## **OXFORDSHIRE COUNTY COUNCIL'S RESPONSE TO CONSULTATION ON THE FOLLOWING DEVELOPMENT PROPOSAL**

**Application no:** 23/01493/REM

**Proposal:** Reserved Matters Application including access, layout, landscaping and scale pursuant to outline planning permission 14/02121/OUT for internal primary and secondary streets along with the partial discharge of conditions 12 (Building for Life 12), 16 (means of vehicular access), 17 (means of pedestrian/cycle links) and 19 (detailed surface water drainage scheme) for Phase 1B

**Location:** Proposed Himley Village North West Bicester, Middleton Stoney Road, Bicester

TITLE
PHASE 1B BUS TRACKING

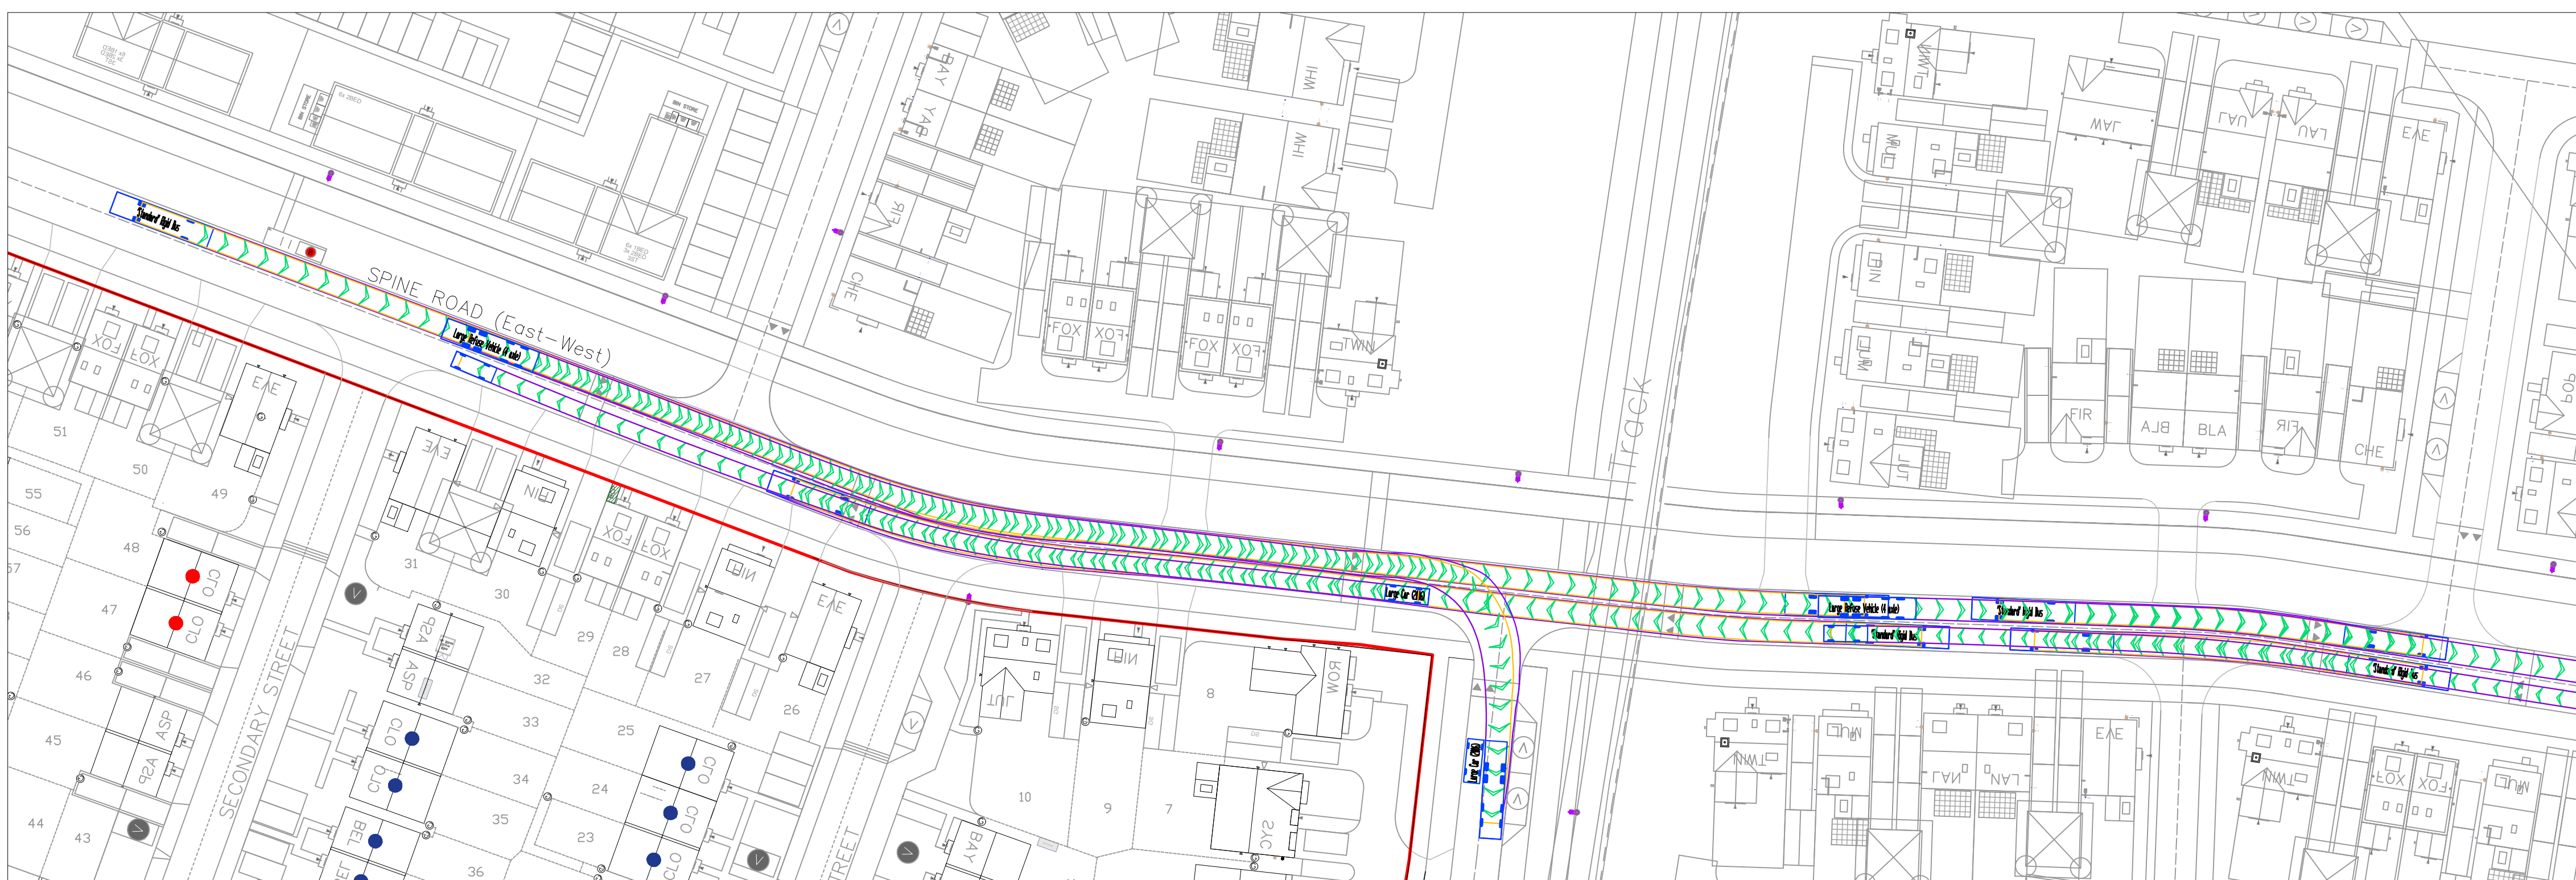
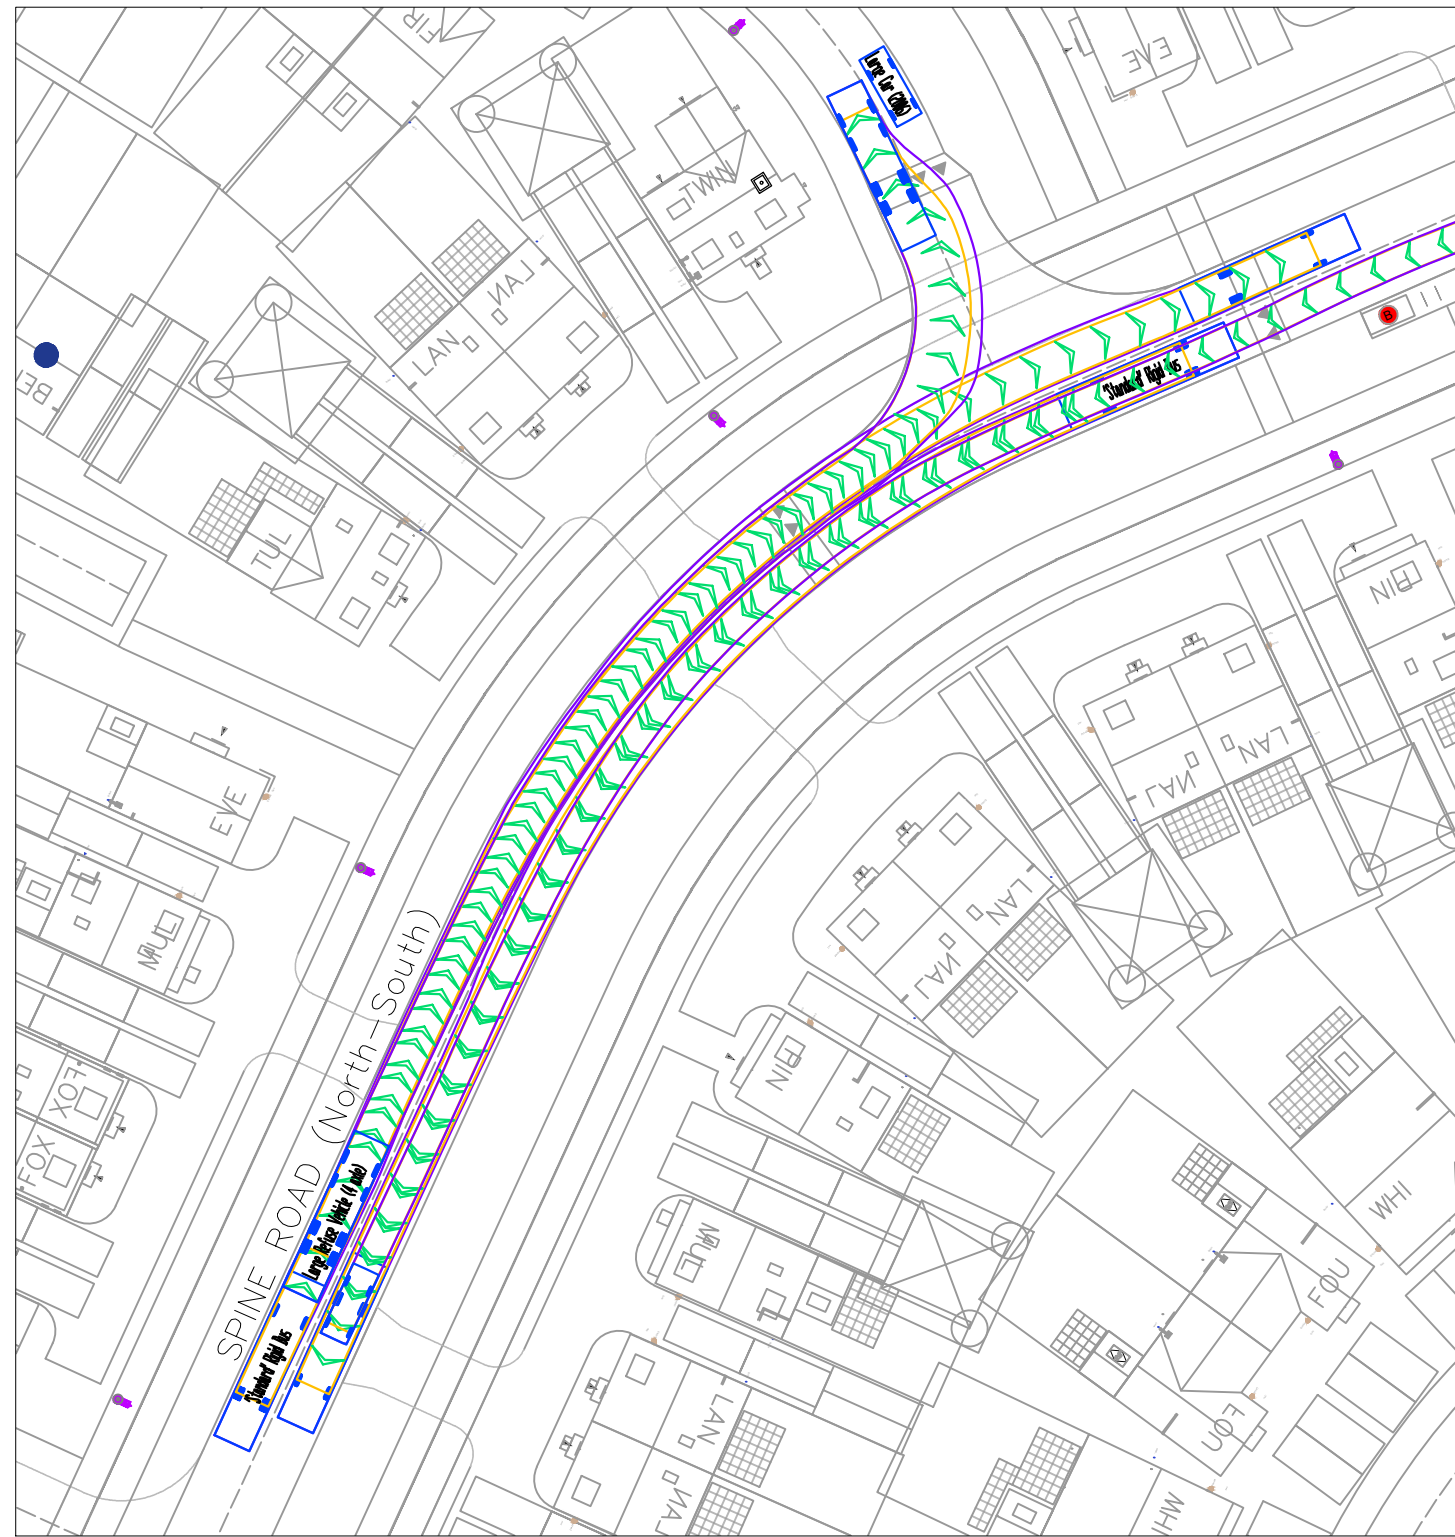
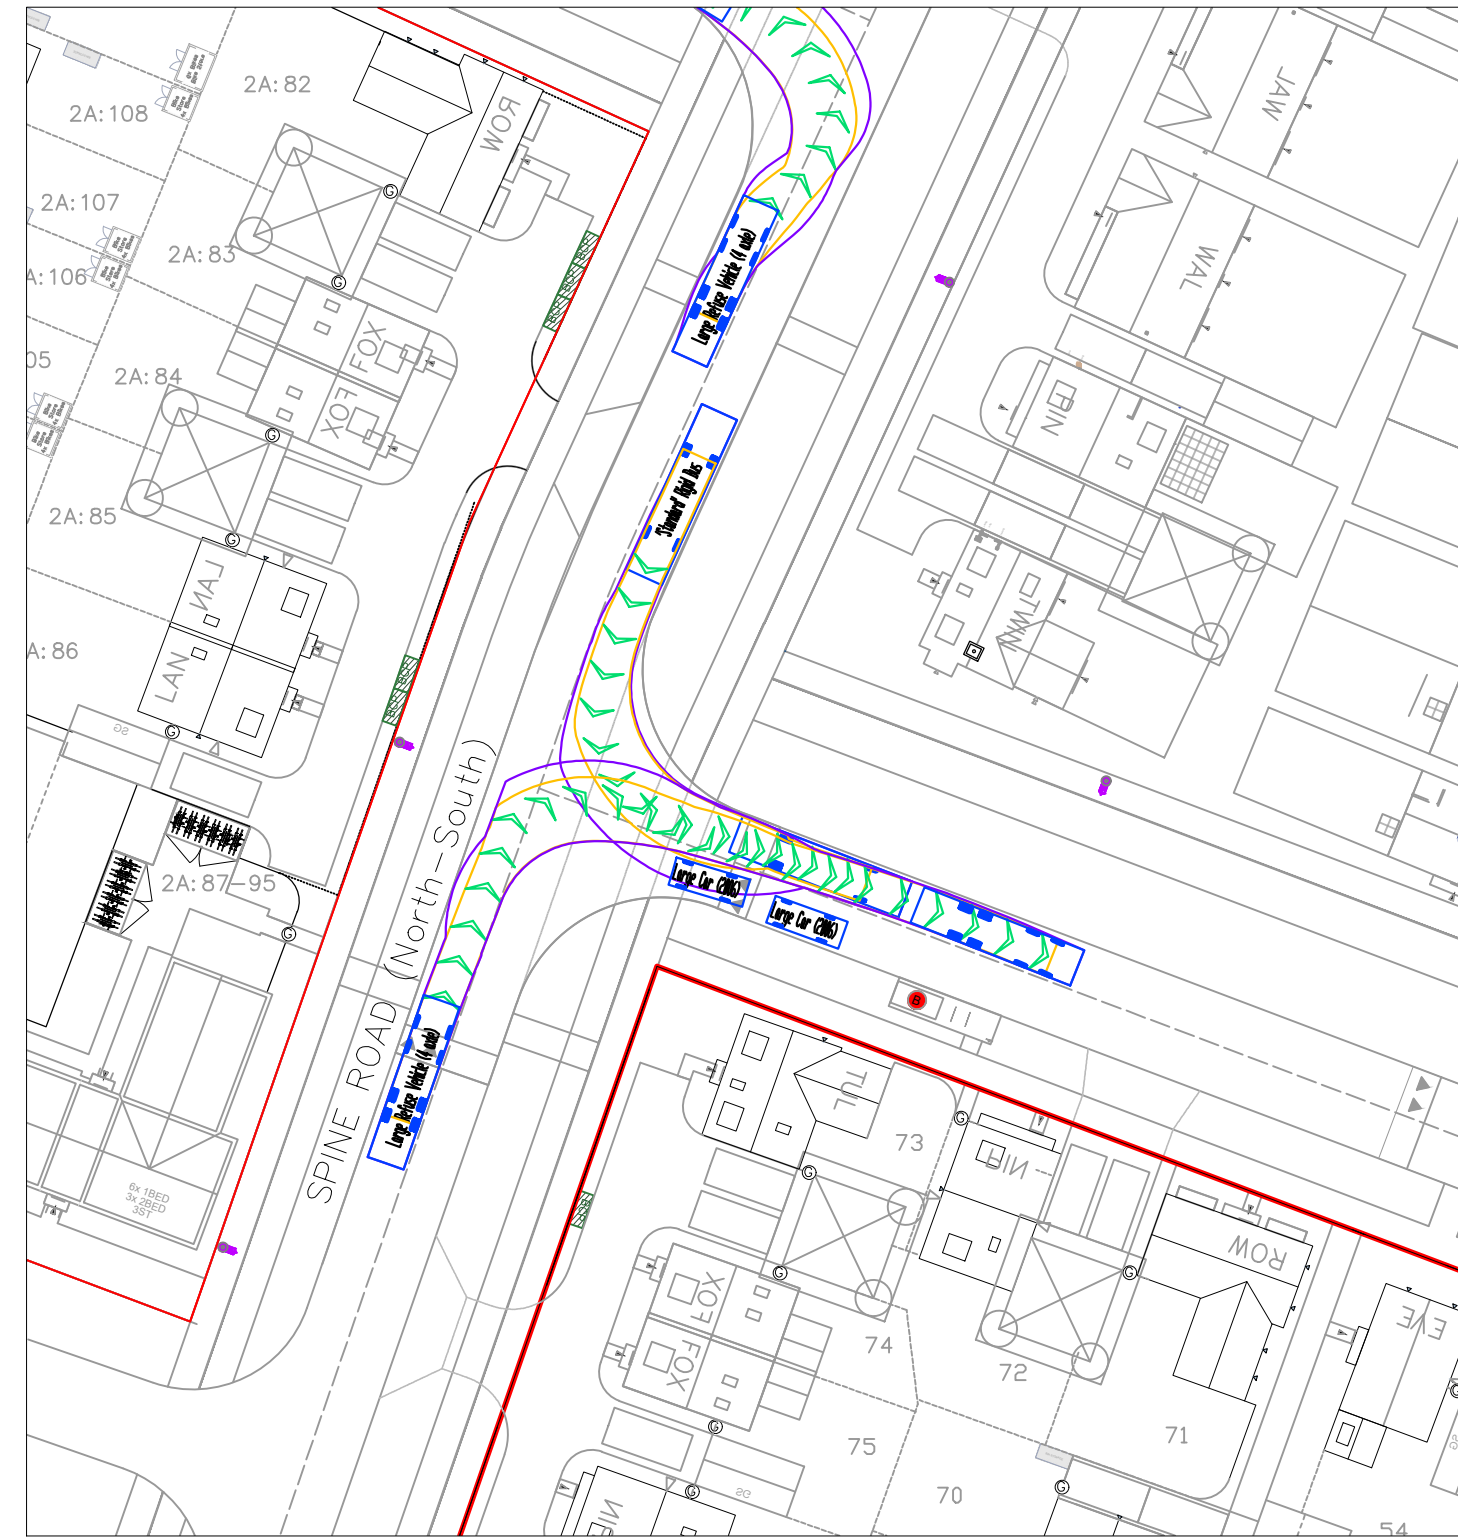
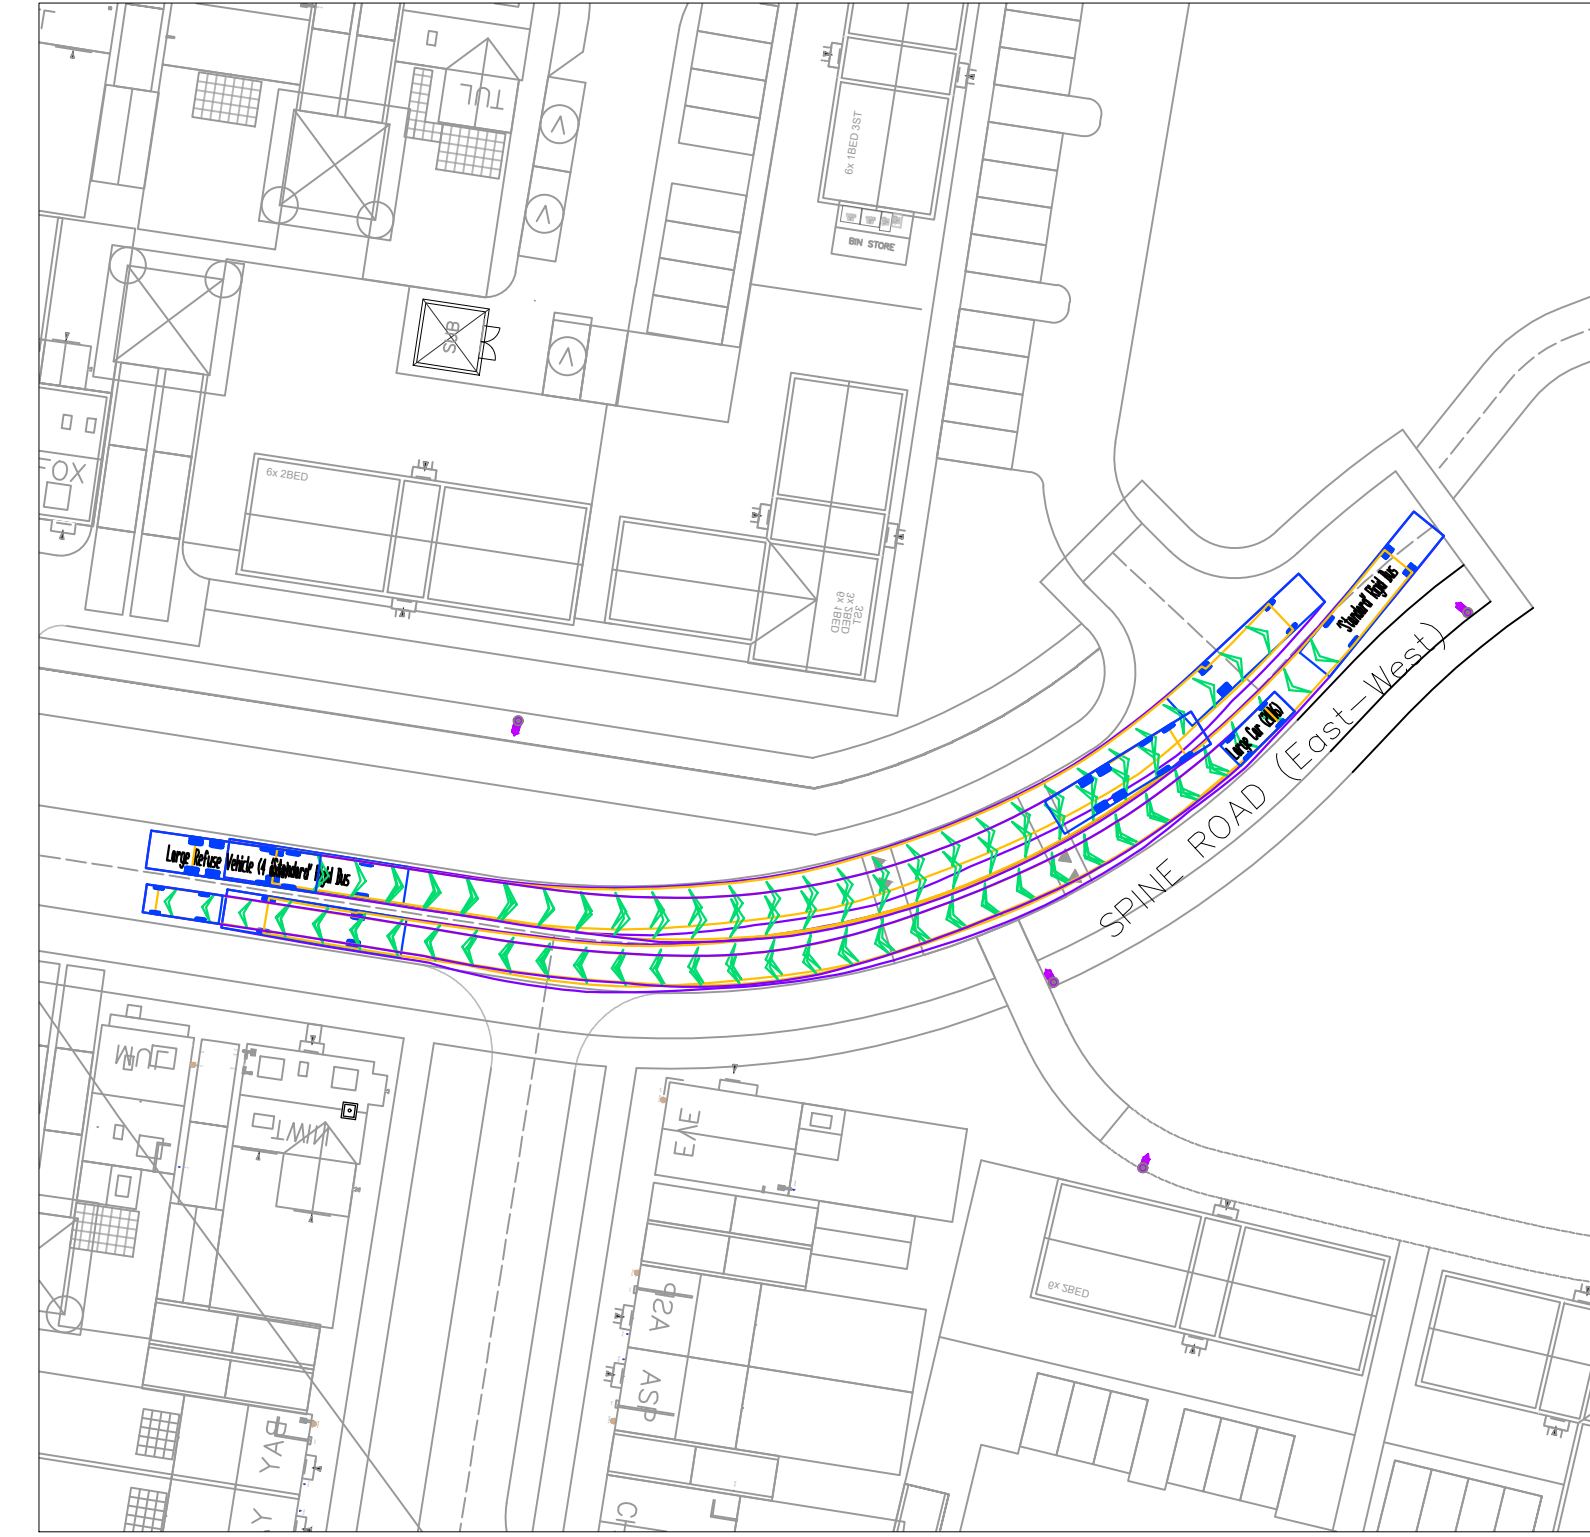
The temporary bus turning heads are not acceptable as it will require buses reversing over the raised cycle crossings which is considered a safety issue. In addition, all wheels will need to face forward and not be at an angle at the turn. Specifically designated independent turning heads should be constructed for buses to be able to turn.
